**RE: Response Letter Regarding
Site Development Plan Comments for the
Stratmoor Hills Water District Centralized Water Treatment Project**

This letter is being provided with submittal of the revised Letter of Intent, Landscape Plan, Lighting Plan, Site Development Plan, and PBMP Applicability Form for the Stratmoor Hills Water District Centralized Water Treatment project identified above. The comments received by the review agencies are outlined below, along with responses regarding requested information.

STRATMOOR HILLS WATER DISTRICT - CENTRALIZED WATER TREATMENT

SITE DEVELOPMENT PLANS
LOT 2, GLENARM SUBDIVISION FILING NO. 2

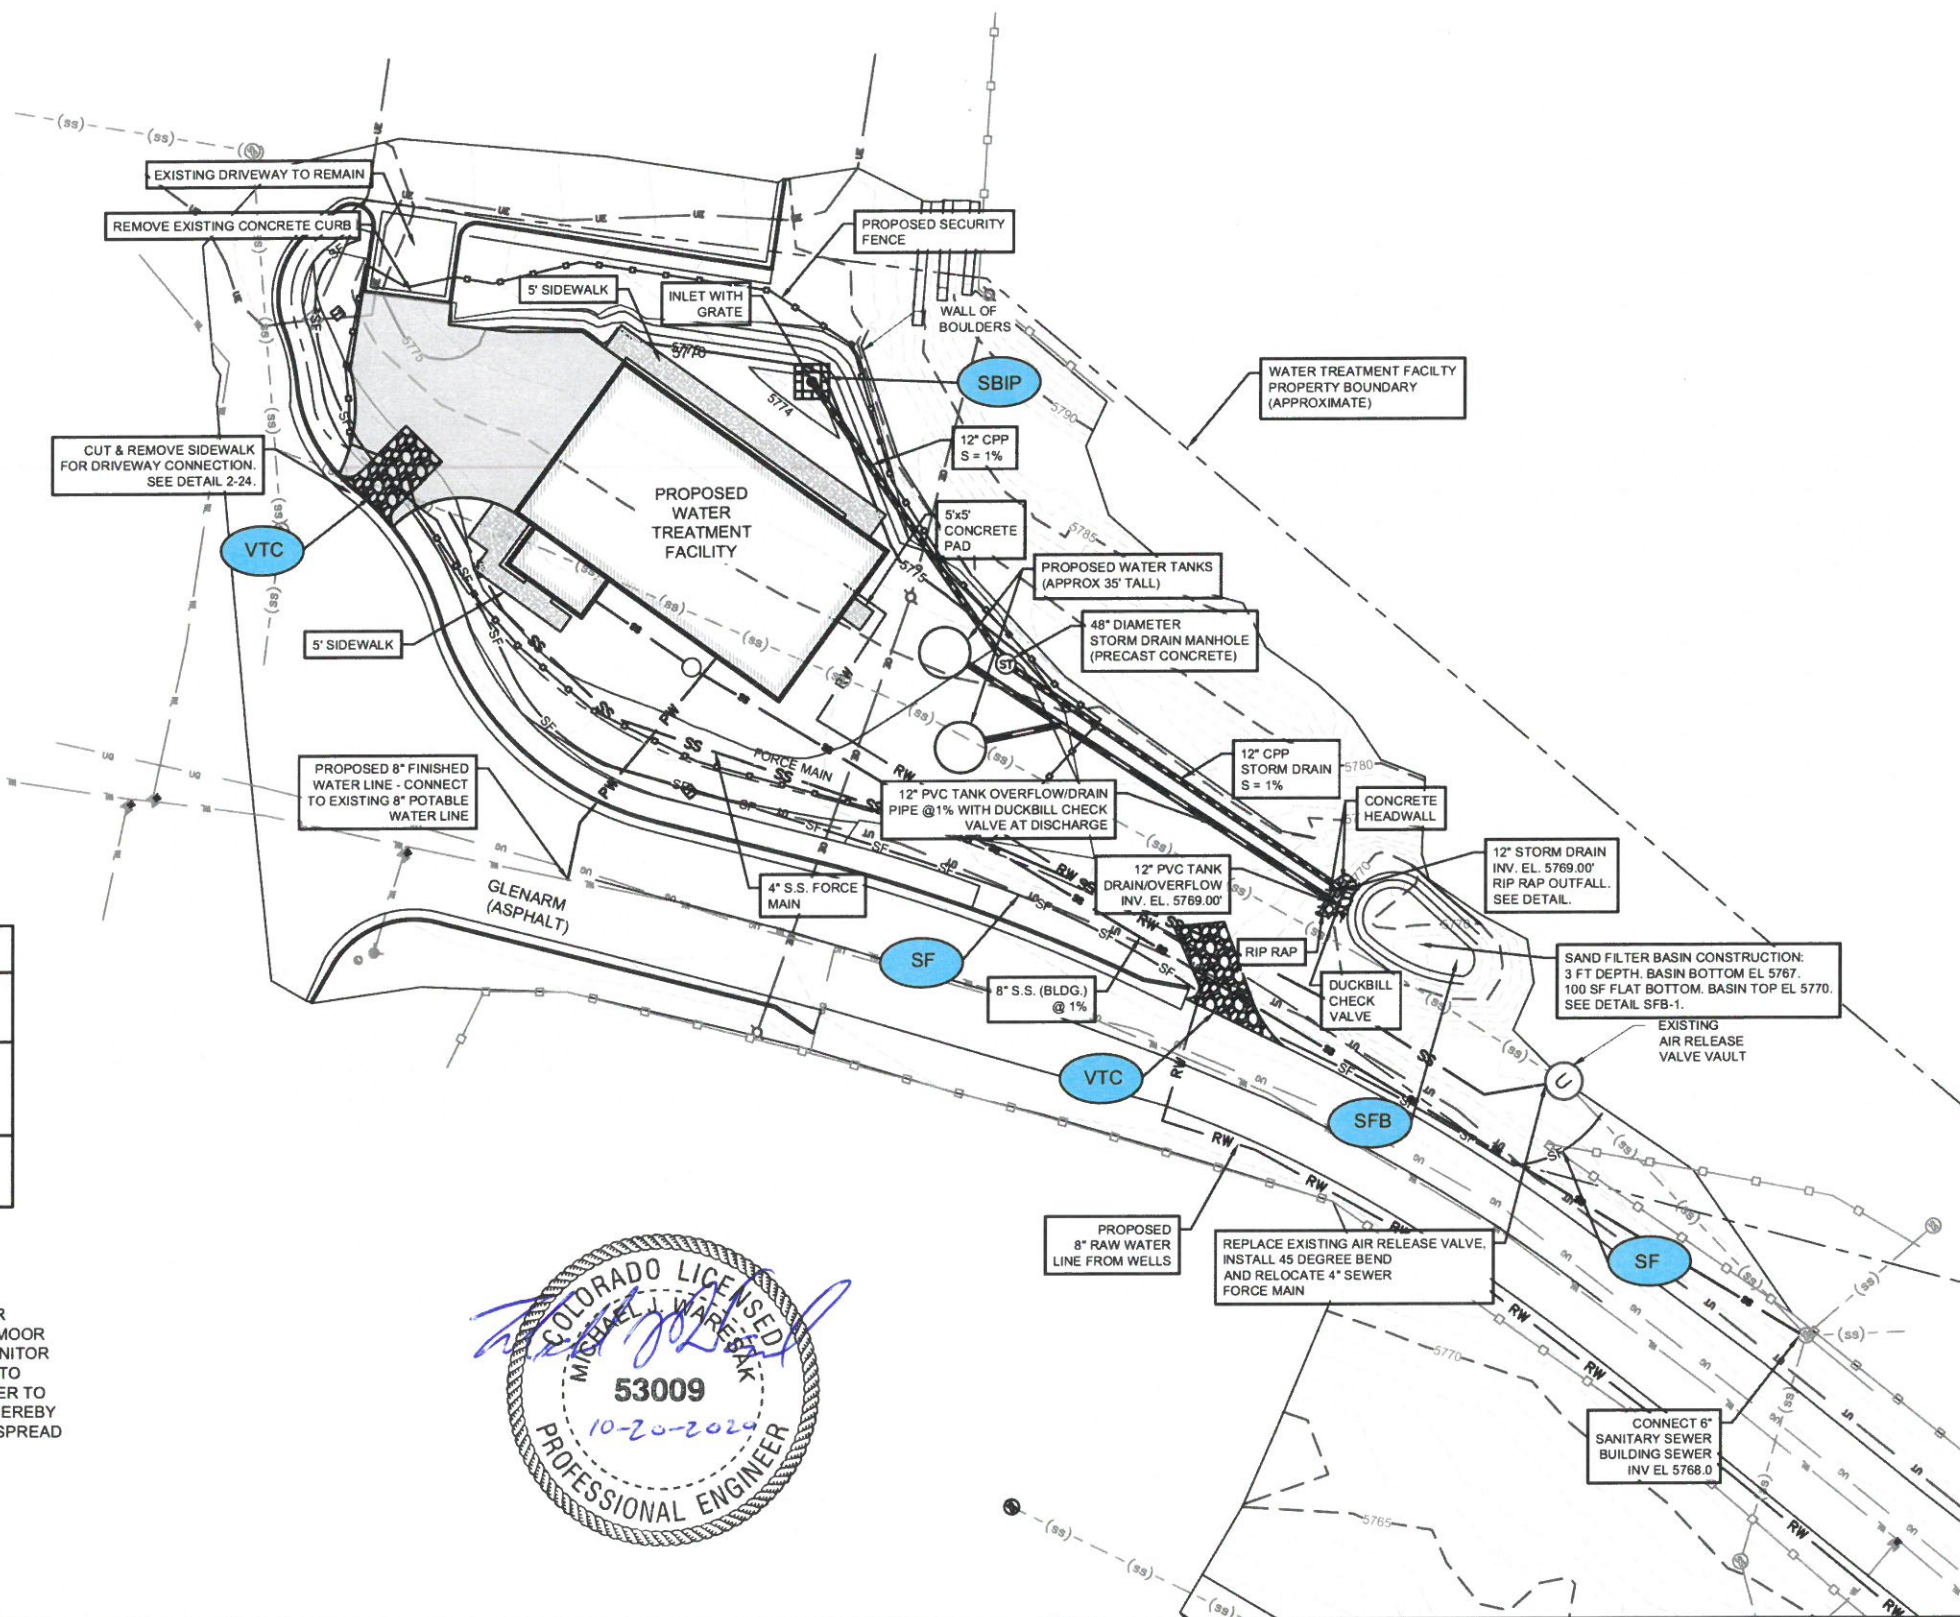
Please provide construction documents to show the proposed grading and the proposed sand filter basin.”

- The centralized water treatment facility for Stratmoor Hills Water District must meet the design criteria and the rules and regulations of the Colorado Department of Public Health and Environment (CDPHE), Water Quality Control Division (WQCD), for water system construction and materials.
- Earthmoving activity in excess of one acre, but less than twenty-five acres, requires a local Construction Activity Permit from El Paso County Public Health. Go to <https://www.elpasocountyhealth.org/service/air-quality/construction-activity-application> for more information.
- The water quality basin must have mosquito control responsibilities included as a part of the construction design and maintenance plan to help control mosquito breeding habitat and minimize the potential for West Nile Virus.

Sand filter basin and grading construction requirements and details are included on the Grading and Erosion Control Plan and Grading and Erosion Control detail sheets.

The comments are acknowledged. A note has been added to the Grading and erosion Control Plan regarding mosquito control.

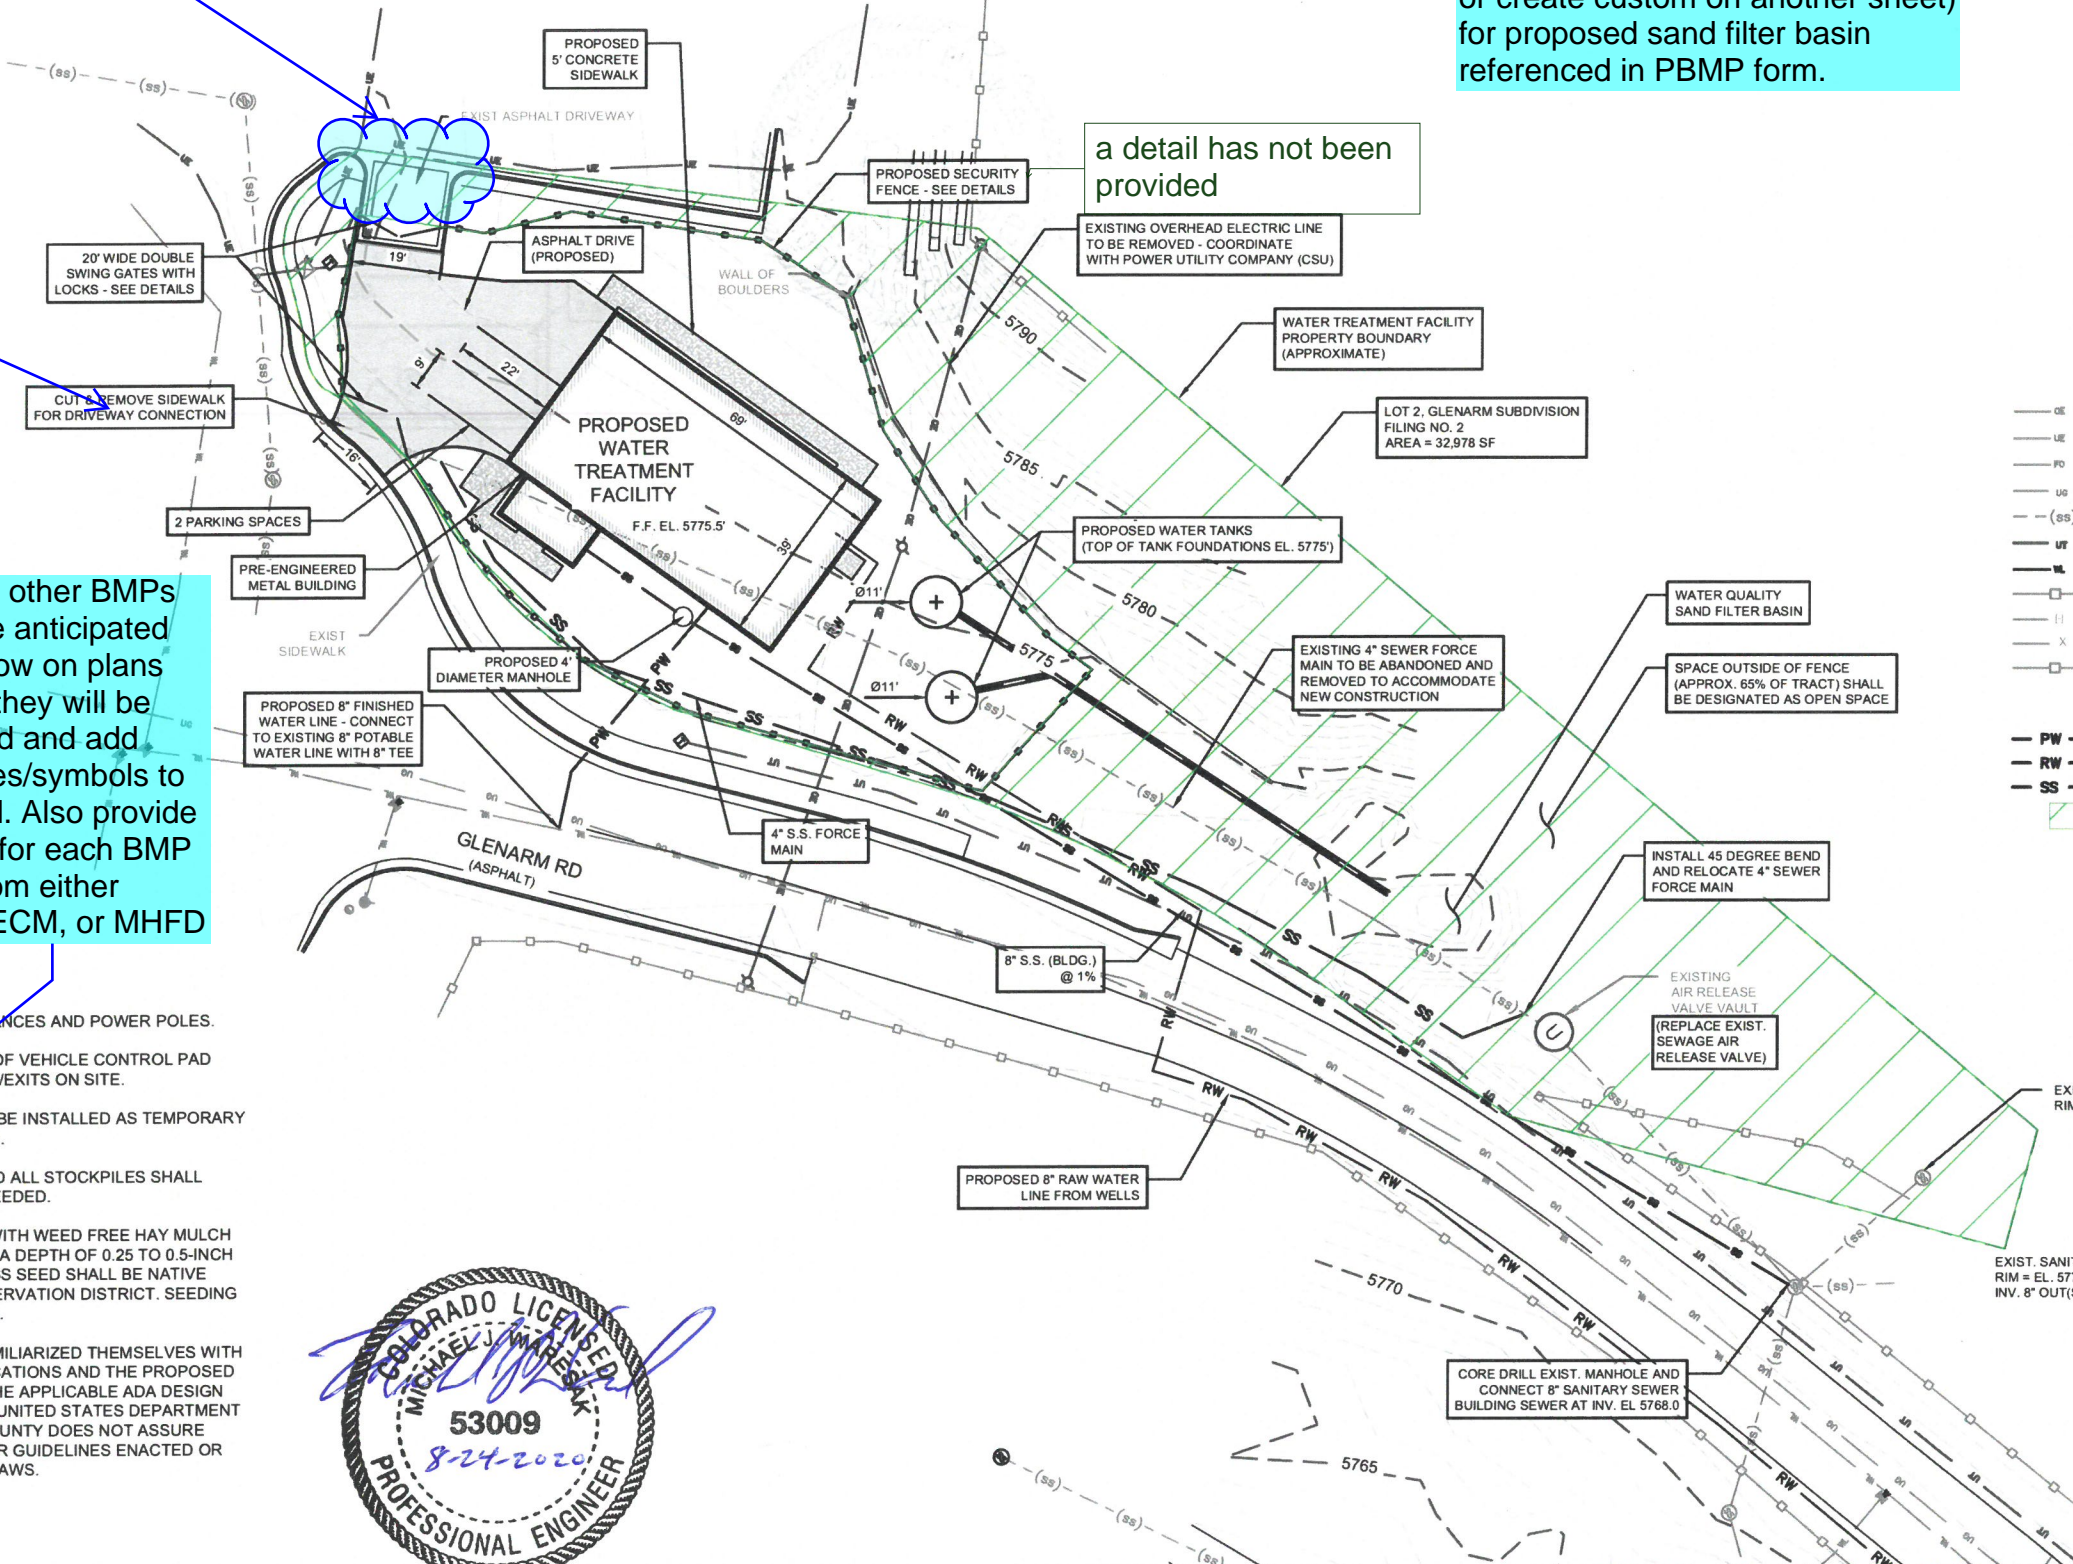
A markup of the Site Development Plan was attached to a comment that reads “Site Development Redlines.” A copy of the Site Development Plan markup is attached to this letter for reference.

Provide details (either DCM/MHFD or create custom on another sheet) for proposed sand filter basin referenced in PBMP form.

Remove existing driveway and install C&G.

Add: Construct per Standard Detail 2-24

List the other BMPs that are anticipated and show on plans where they will be installed and add linetypes/symbols to Legend. Also provide details for each BMP type from either DCM, ECM, or MHFD

Provide VTC detail (see EPC detail VT-1 and VT-2, or MHFD detail SM-4) and also show locations on plans

All redline comment have been addressed in the revised Site Development Plan.

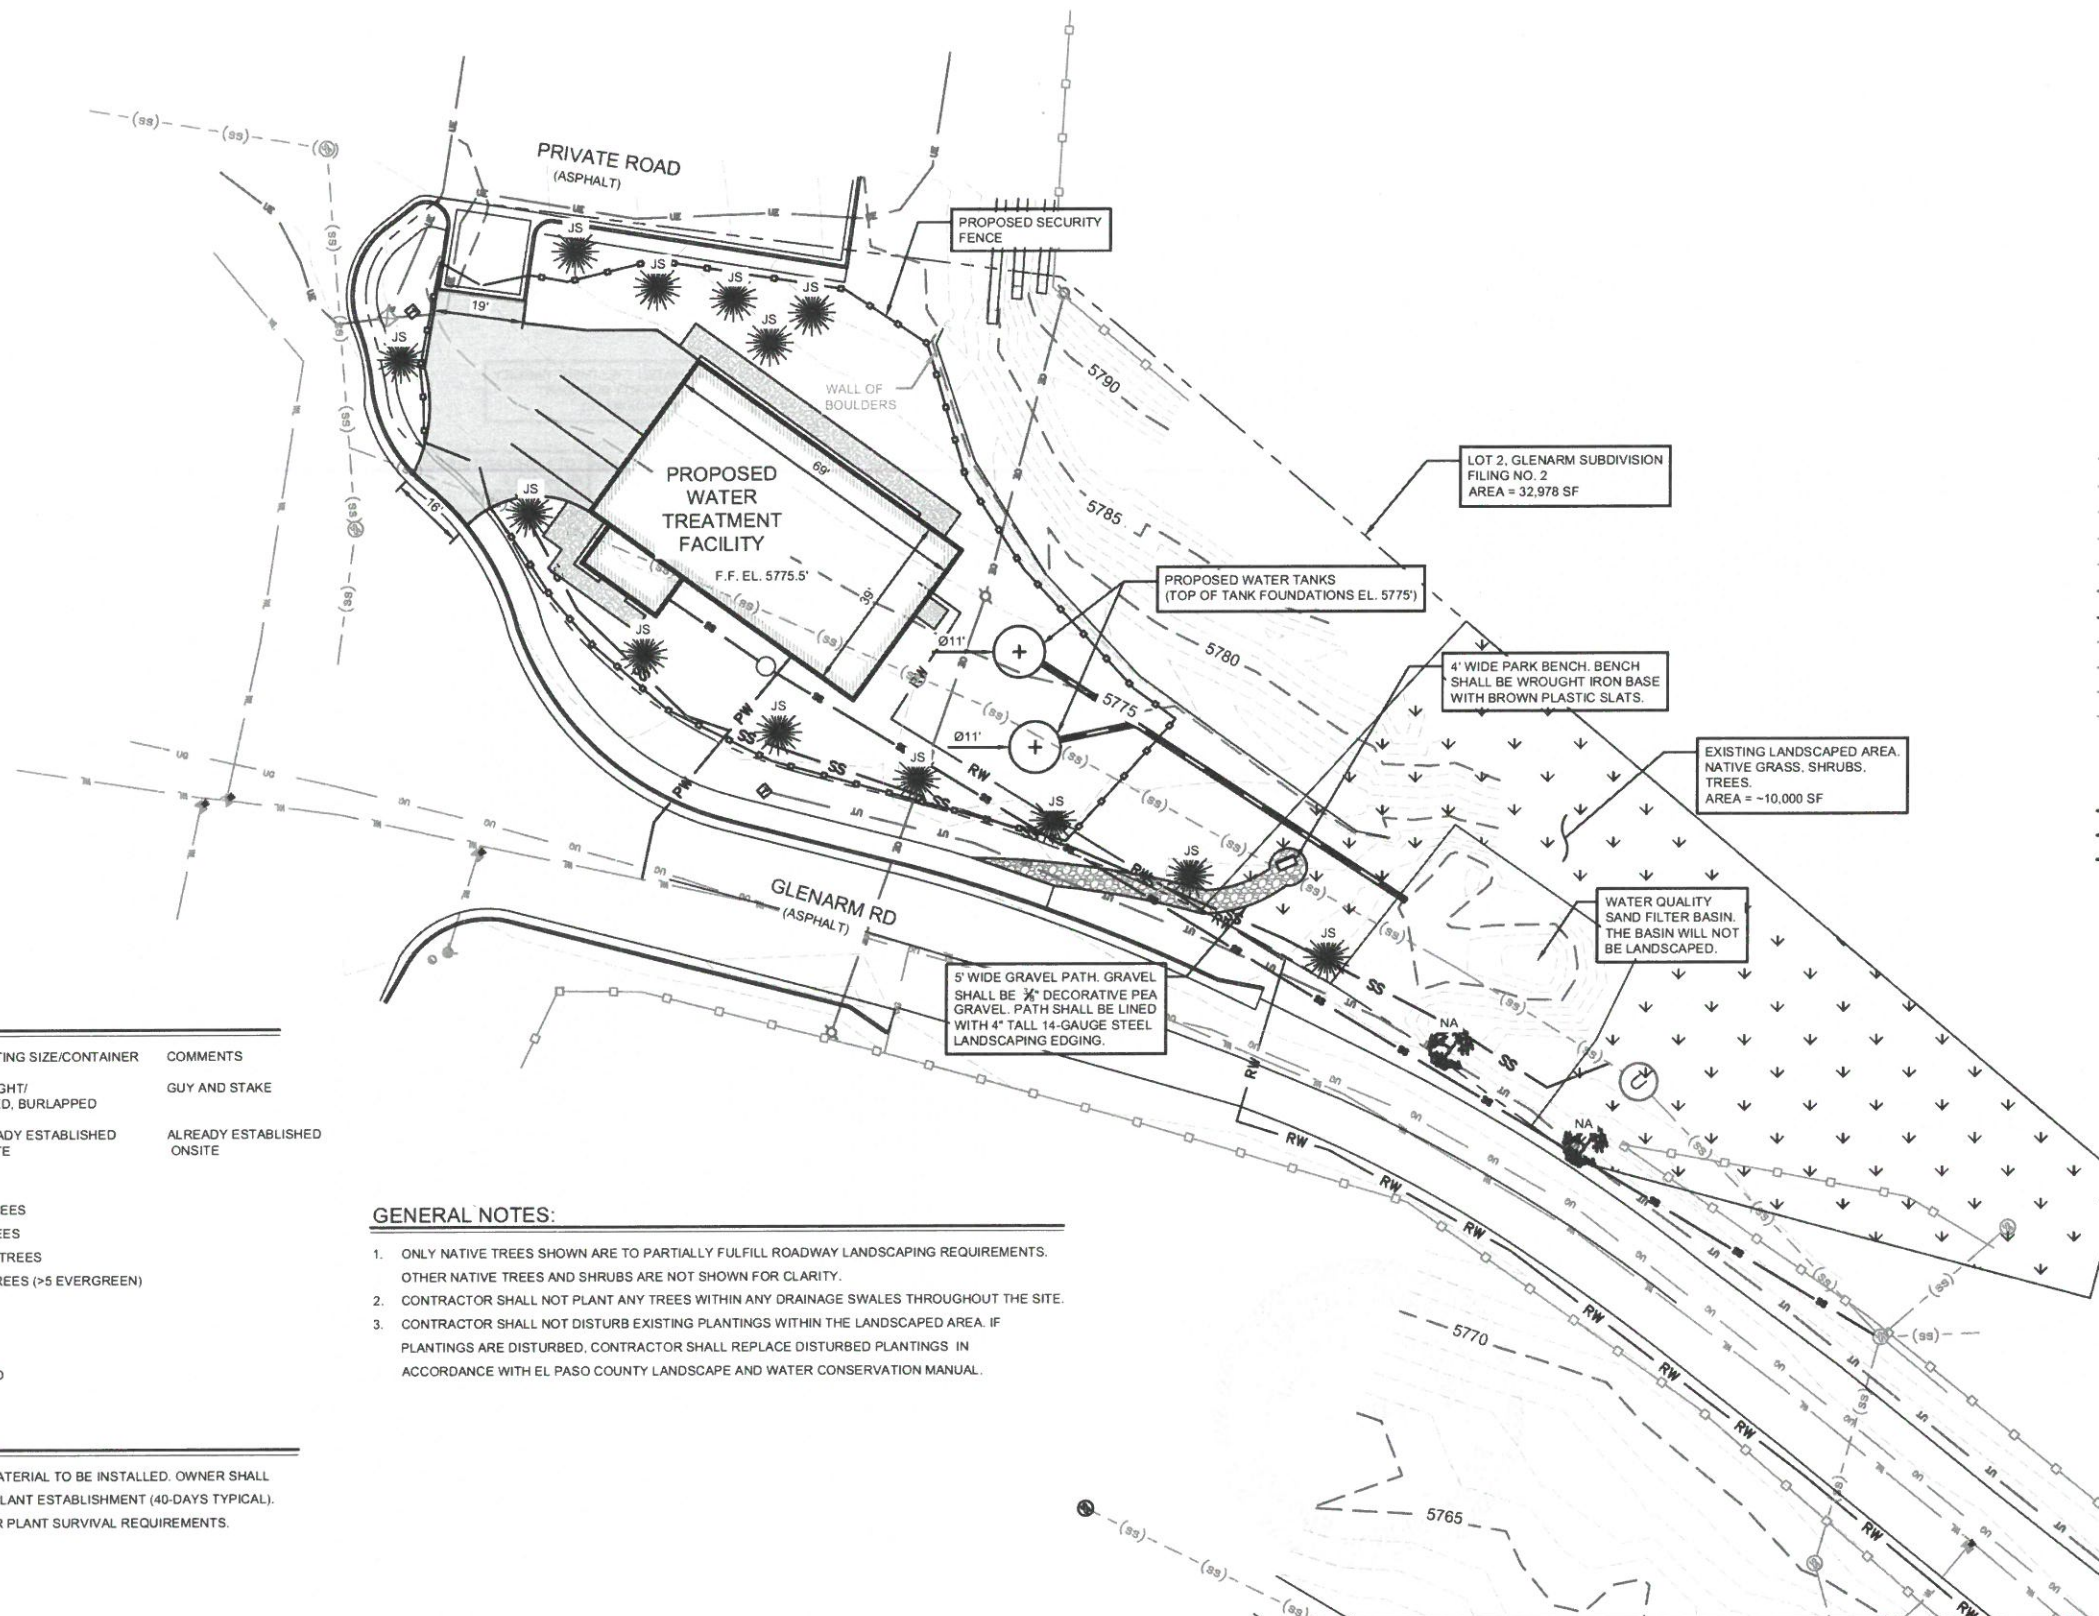
1. The landscape plan does not include a key identifying the proposed plant types. Please add.
2. The LDC requires fencing and landscaping adjacent to differing land uses and/or zoning districts. The proposed plan does not comply with this requirement, however, this is not a traditional commercial use. Staff recommends requesting an alternative landscape plan with justification in your letter of intent.
3. The PUD requires this area to be used partially or wholly for common open space. A large portion of the site is open and undeveloped. In order to satisfy the PUD requirement please add a park bench/picnic table/trail or similar to the undeveloped portion.
4. Please provide a detail of the proposed lights.
5. Please add an ADA route to the site plan.”

1. A key identifying plant types was added to the Landscaping Plan legend.

3. A walking path and park bench have been added to the open space, as shown on the Landscaping Plan.
